Include the Sign plan on this submittal item,
not in the application, scan the documents
better, I cannot read them.

Indicate which sign
this application is
for. put parcel
boundaries on
aerial.

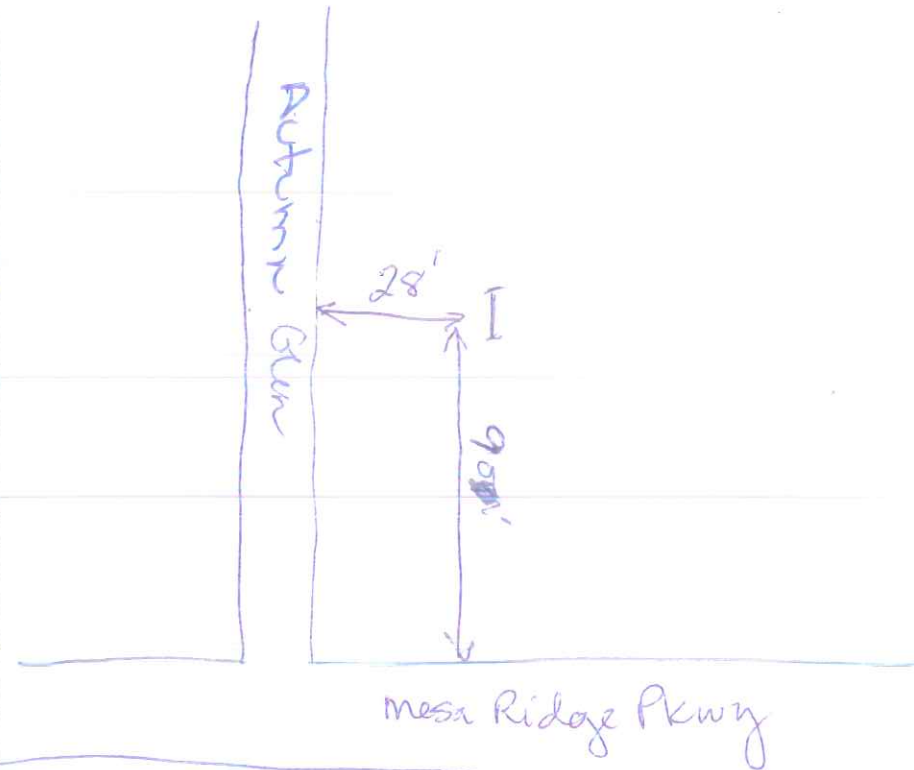
Include the Sign plan on this submittal item, not in the application, scan the documents better, I cannot read them.

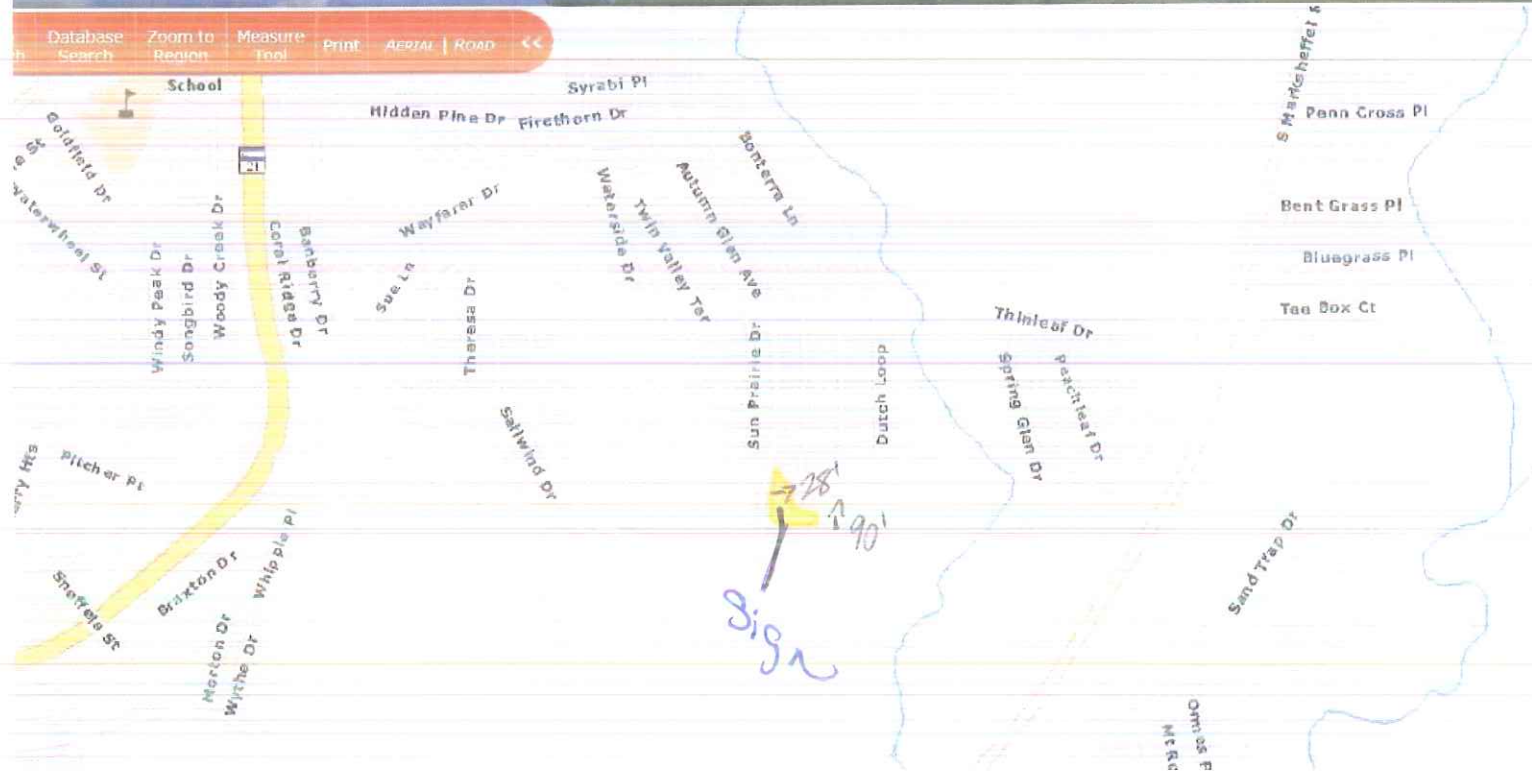
Indicate which sign this application is for. put parcel boundaries on aerial.
